April 26, 2022

Re: Pima Medical Institute New Class Room Building
4400 Cutler Ave. NE
Traffic Circulation Layout
Architect's Stamp 4-28-22 (H17-D054B)

Responses to TCL Review Comments, Revision 4

TCL001

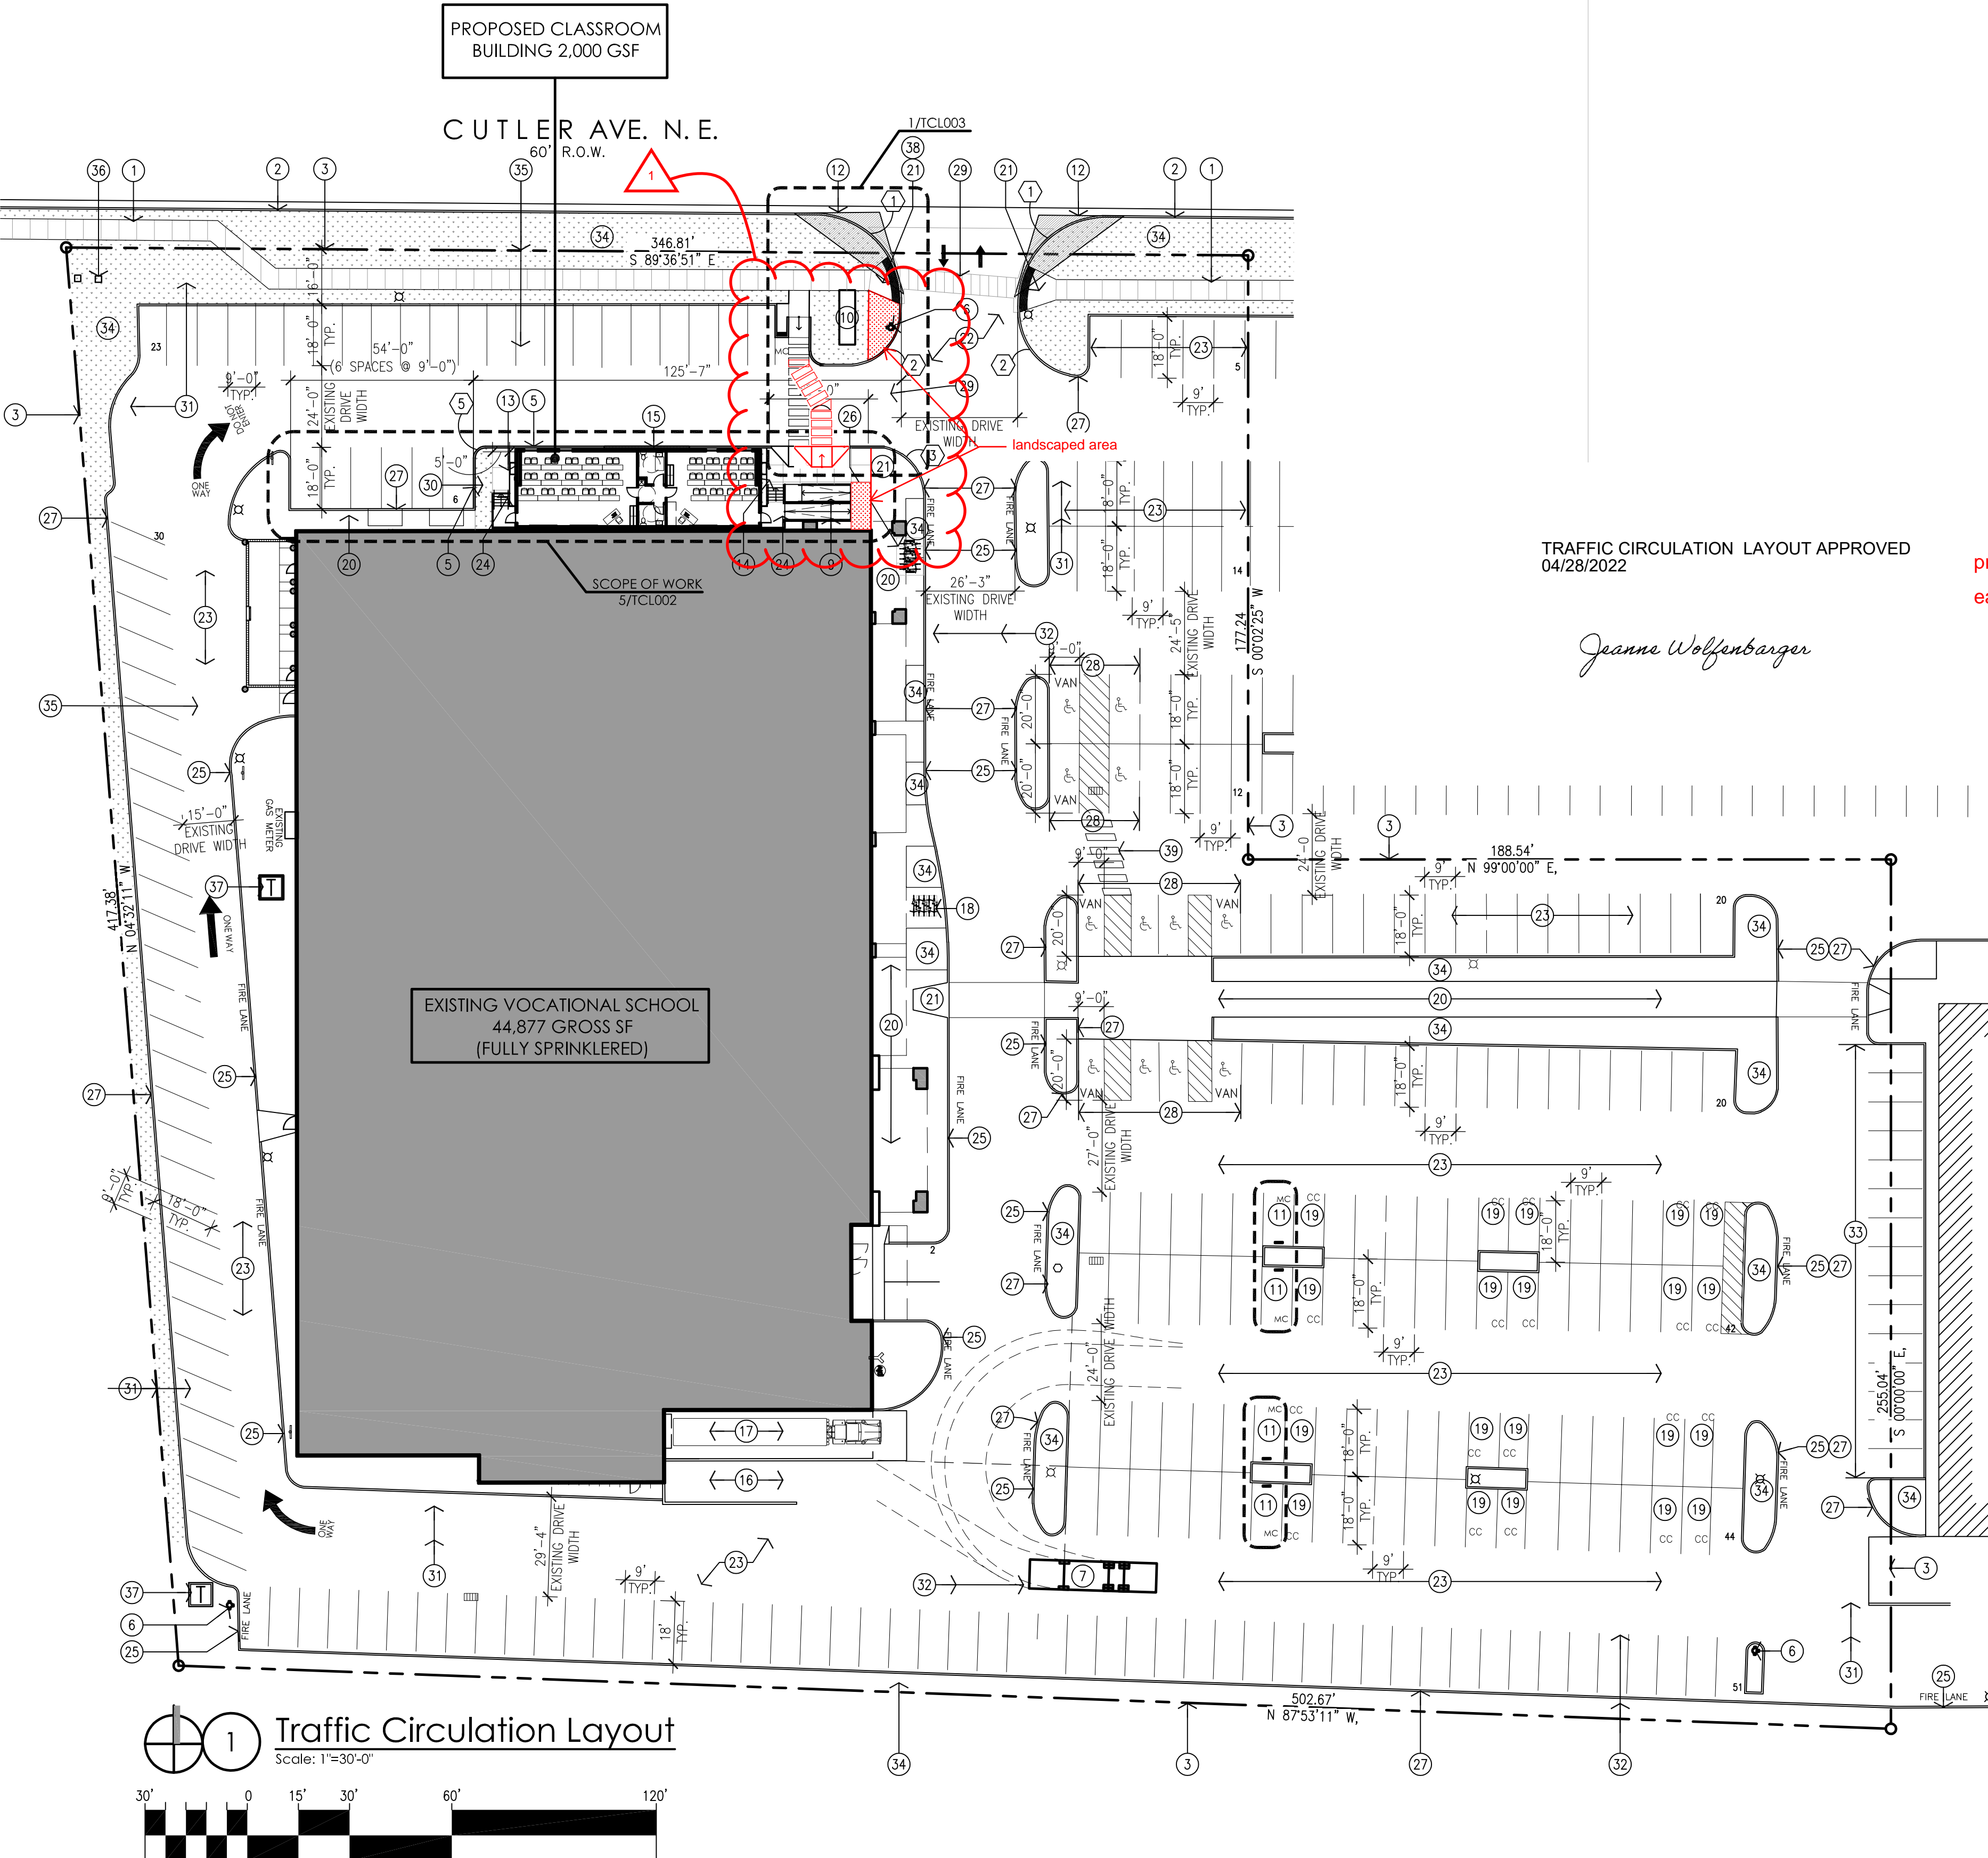
The TCL submittal received 04-20-2022 is approved for Building Permit with. A copy of the stamped and signed plan will be needed for each of the building permit plans. Please keep the original to be used for certification of the site for final C.O. for Transportation. **Prior to Certificate of Occupancy, please have the city sidewalk easement in place as requested by Mr. Salgado.**
